RE: APPLICATION FOR VARIATION OF CONDITIONS UNDER SECTION 73 OF THE TOWN AND COUNTRY PLANNING ACT 1990

Planning Reference: 2023/62/92557/W

Site Address: Cellars Clough House, Marsden, Huddersfield, HD7 6LY

rev	date	description			
Project <b>CELLAR CLOUGH HOUSE, MARSDEN</b>					
Title <b>ELEVATIONS AS PROPOSED</b>					
Project No	23-07	Drawing No	L(-4)021	Status	PLANNING
Scale	1:100@A3	Date	JULY 2023	Rev	01

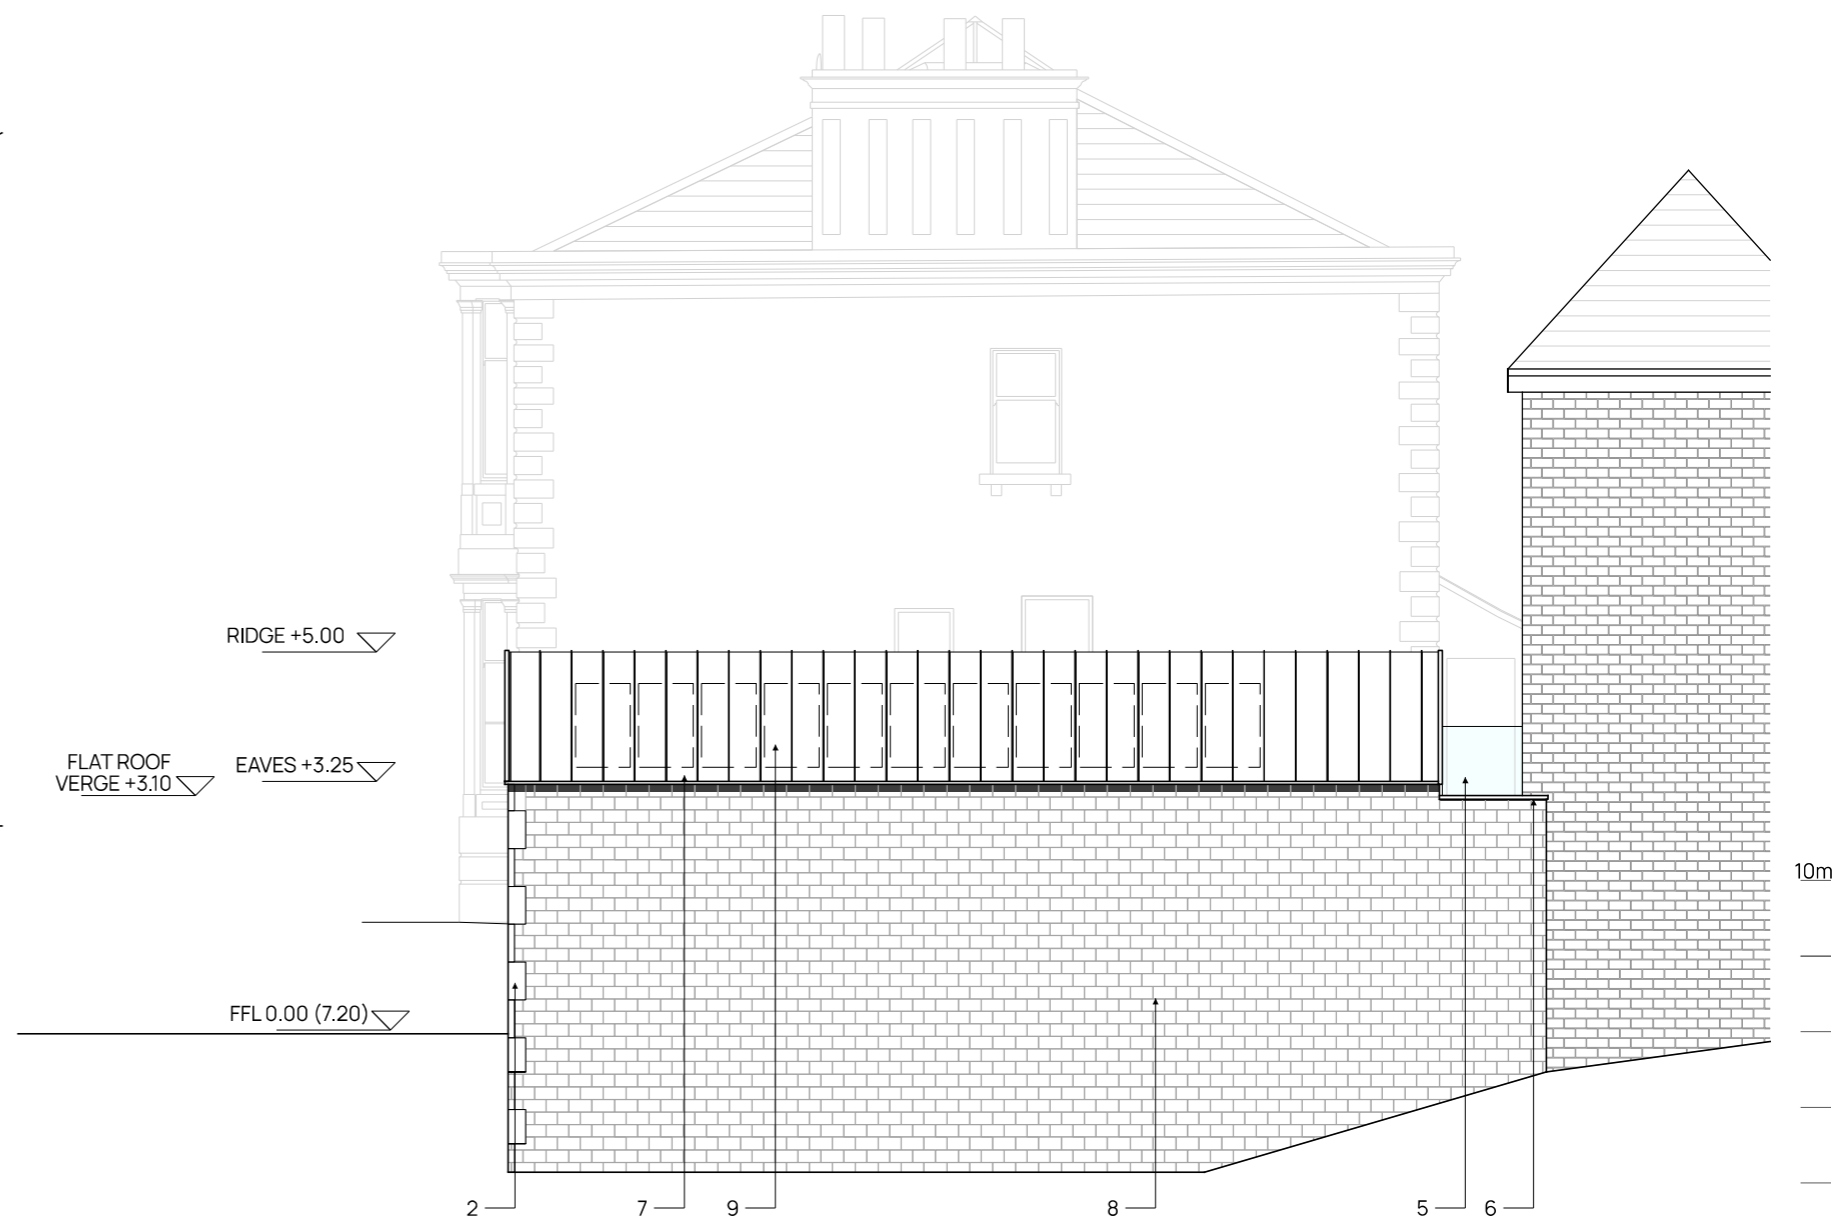
We are also proposing to replace the old elevation drawings with new ones. Due to technical requirements, we are proposing to increase the height of the parapet on the flat roof, and as a result the vaulted roof height too, by 350mm. This helps facilitate all the detailed aspects of the scheme, driven by the flat roof and the roof terrace above (allowing enough depth for structure, insulation, drainage, pedestals / supports). We are also proposing to increase the length of the vaulted roof slightly, to give more height to the pool area below.

Drawing No GSL3324_GDR_DWG001	Revision A
----------------------------------	---------------

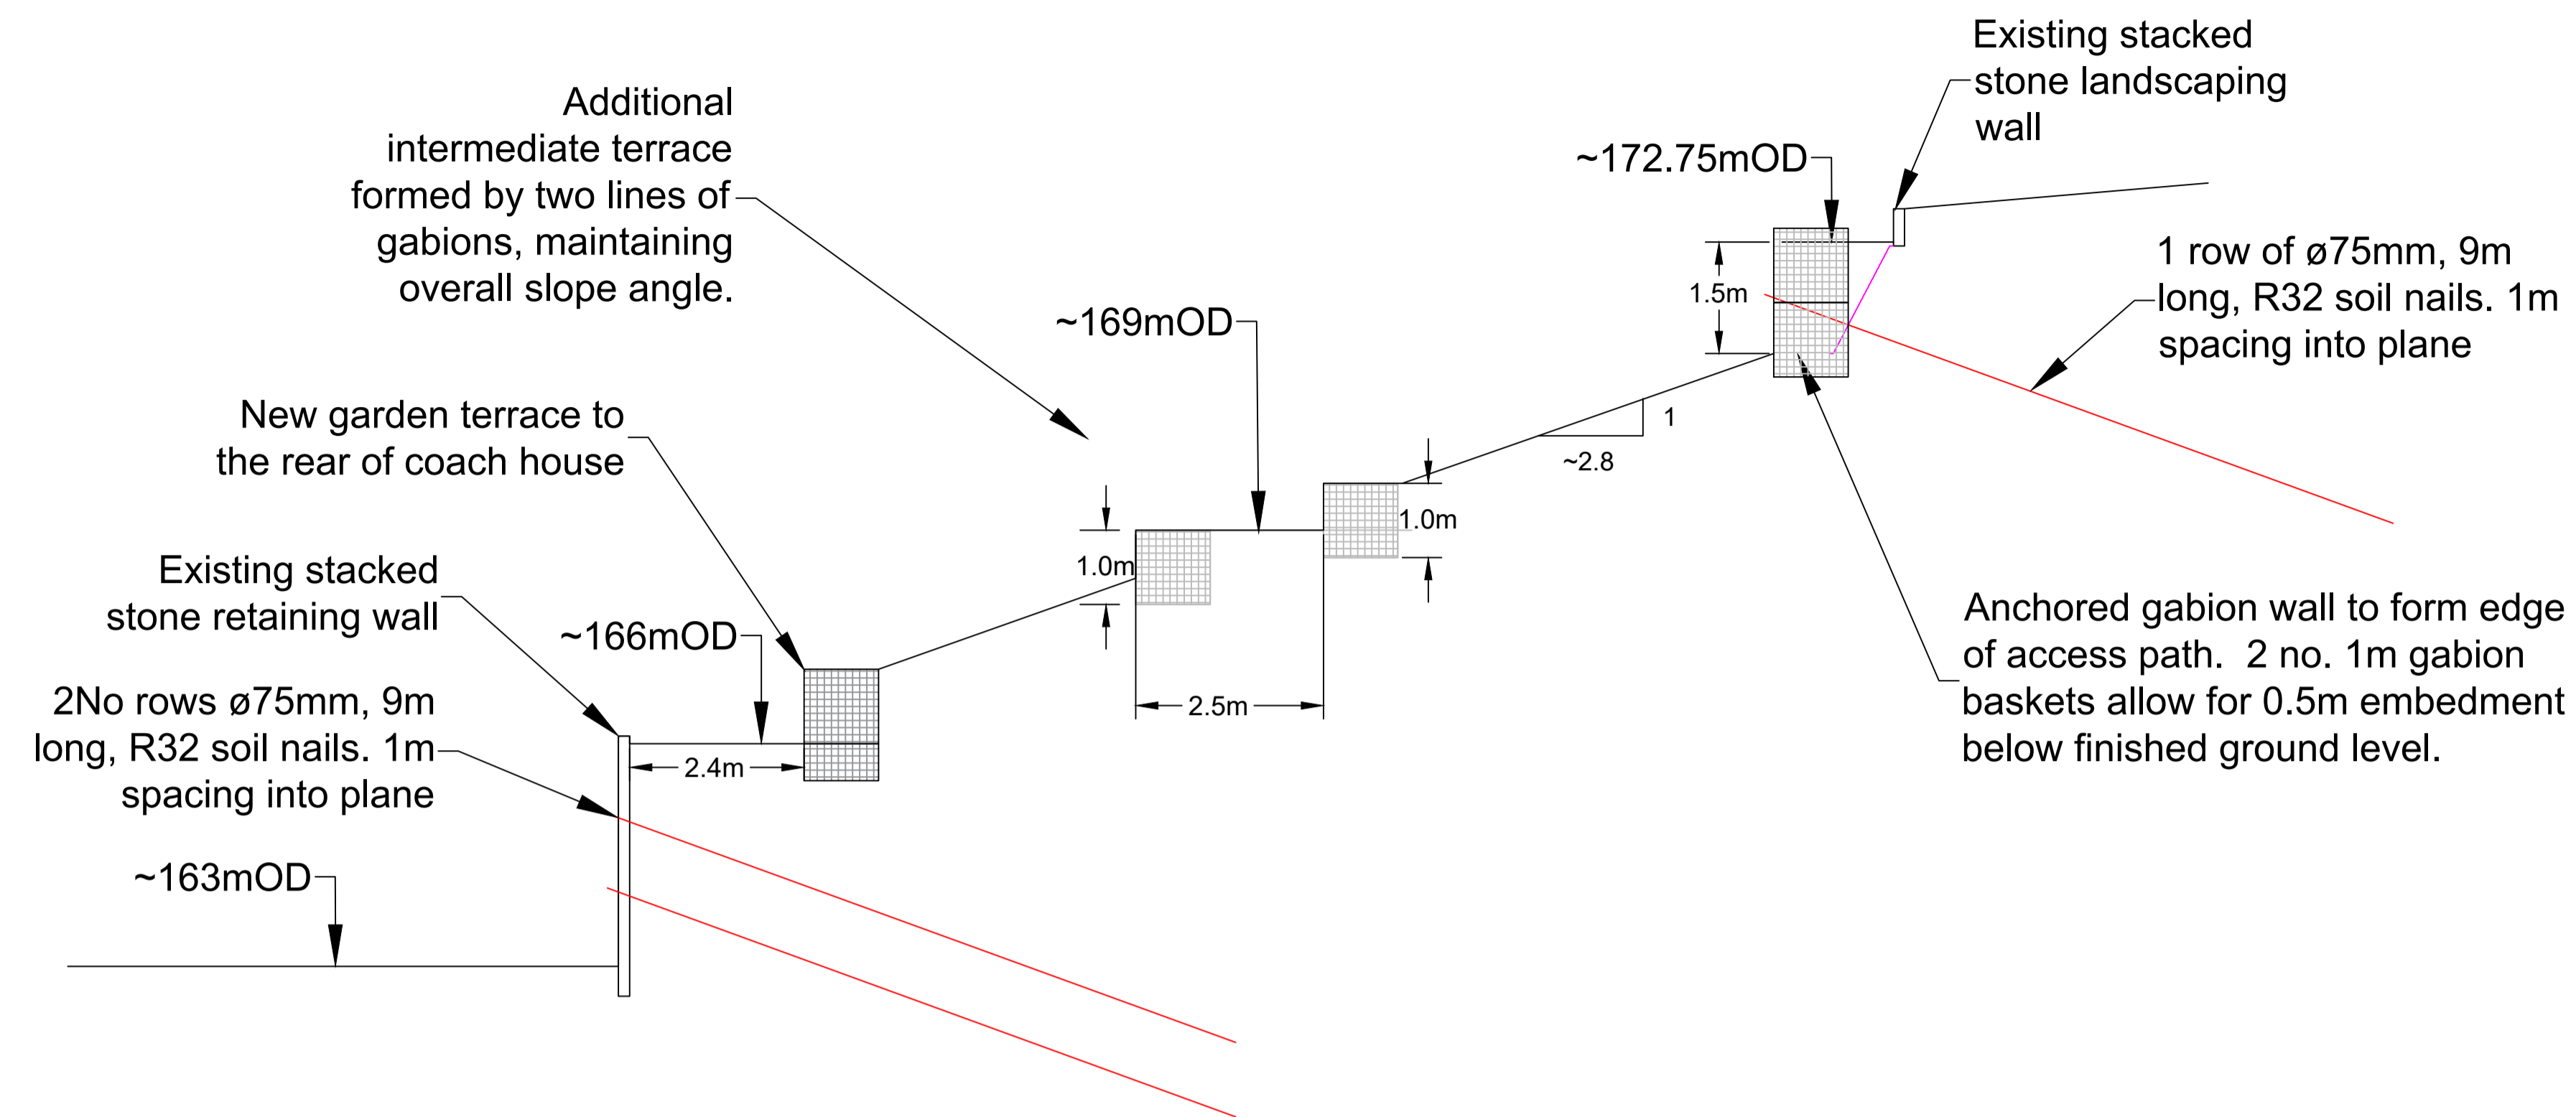
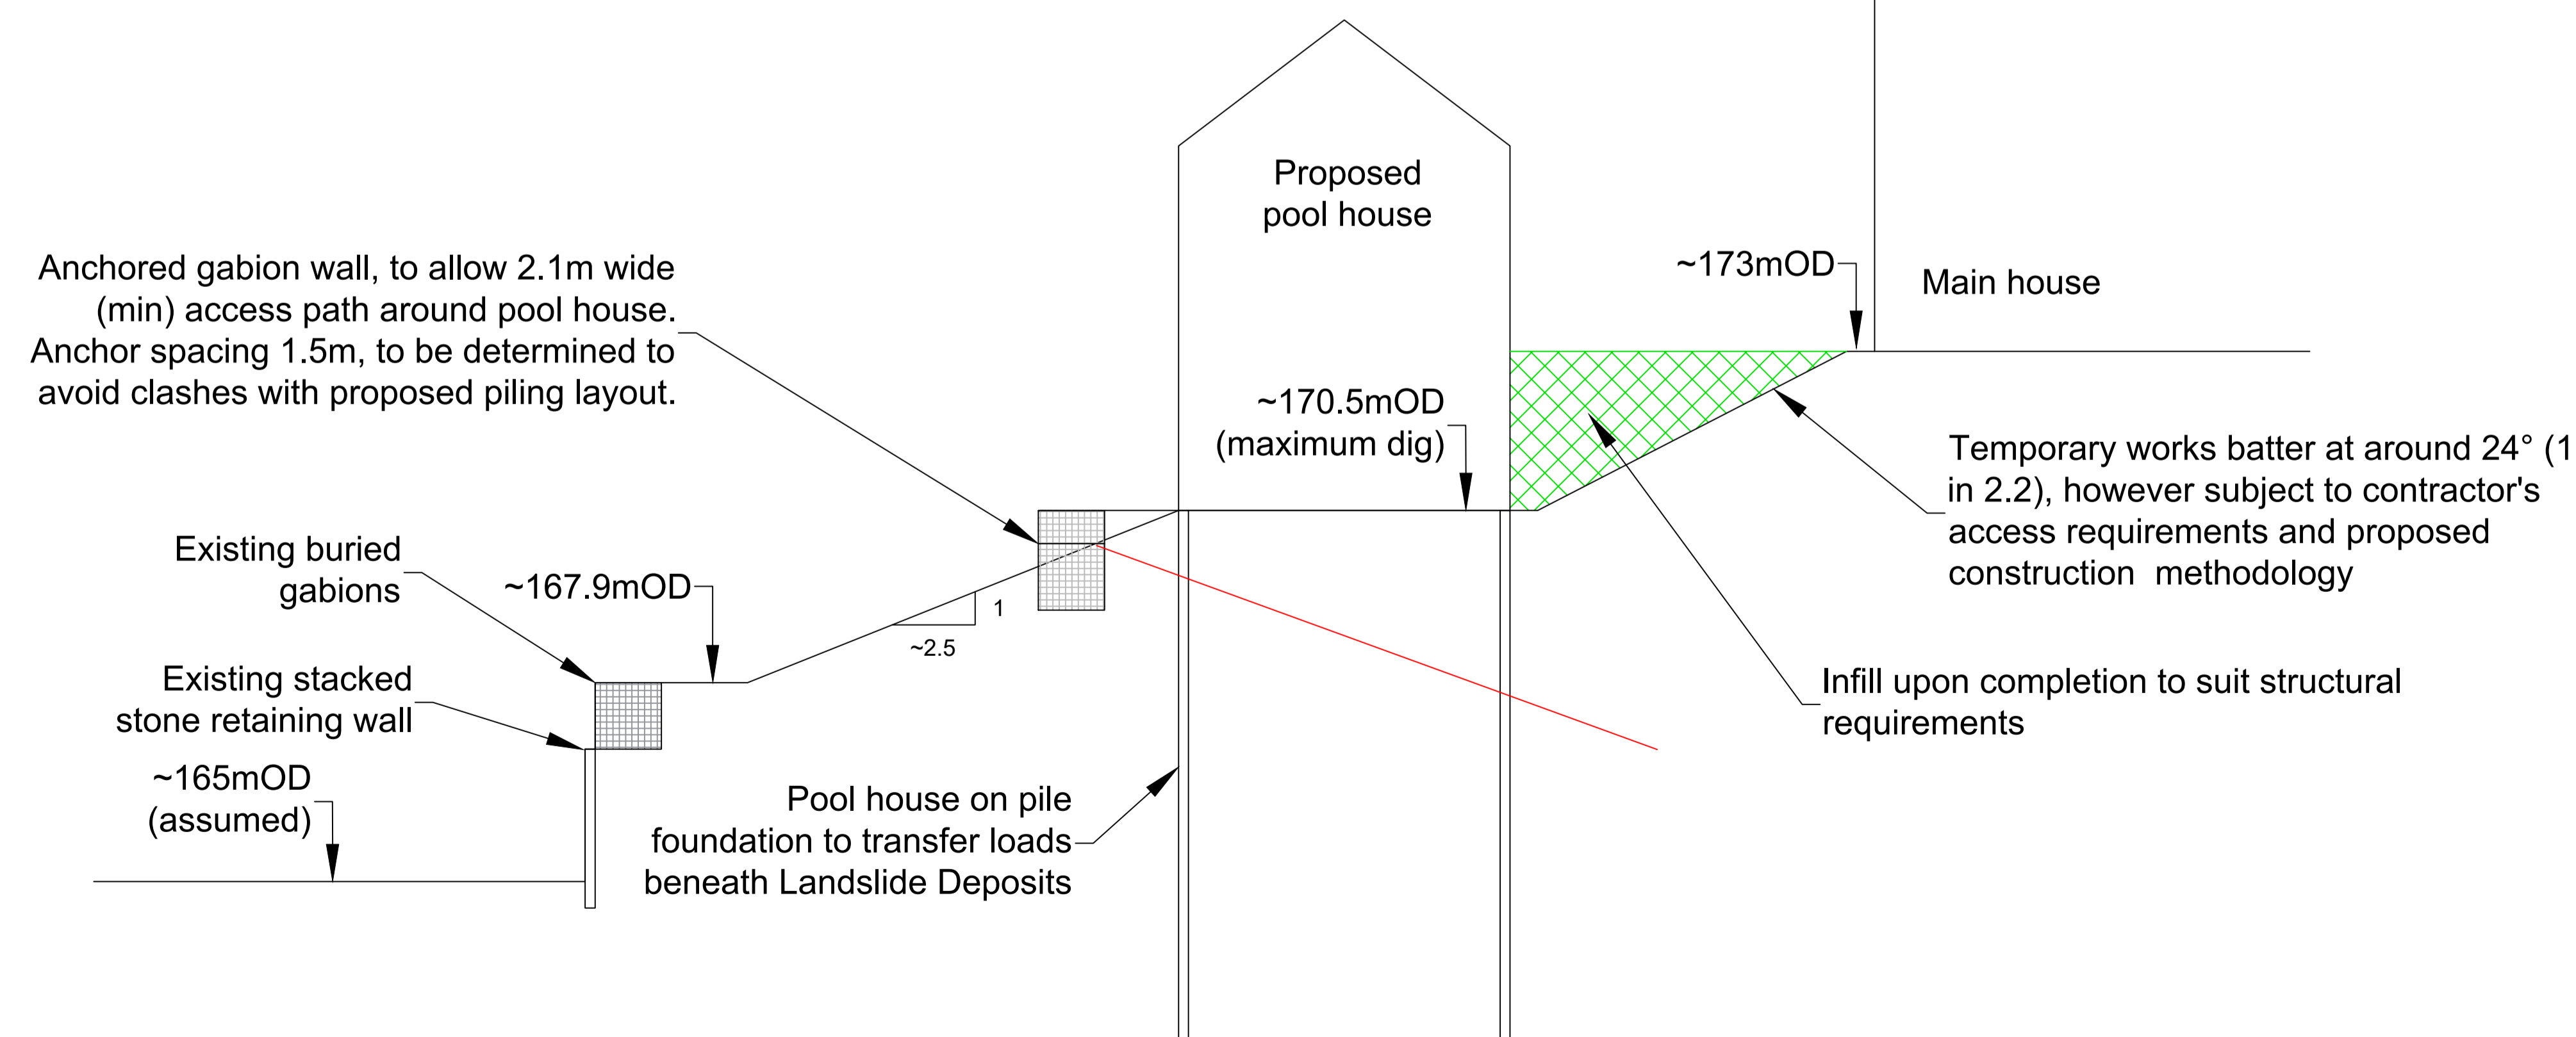
Condition 5 stipulates that all works relating to land stability should be in accordance with the details submitted. However, since the application was approved, a different geotechnical consultant was appointed to the project who has put forward an alternative proposal for the slope stabilisation than the one approved under the above application. We would therefore like to amend the drawing and document references named in the condition to refer to the new documents submitted by the Geotechnical Consultant, which reflect the new design.

Proposed Wording: *"All works hereby approved that relate to land stability shall be undertaken in accordance with the details as submitted in drawing numbers GSL3324_GDR_DWG001 and GSL3324_GDR_DWG002 and the details as contained within the Geotechnical Design Report (reference GSL_3324_GDR_001_Rev3) which shall be retained thereafter."*

The revised stabilisation method continues to address land-stability requirements and does not alter the building footprint or its relationship with the surrounding landform. The submitted layout that has been discussed and agreed with the neighbour at Coach House Healing & Wellbeing Centre. Drawings DWG001 and DWG002 are contained within the report.
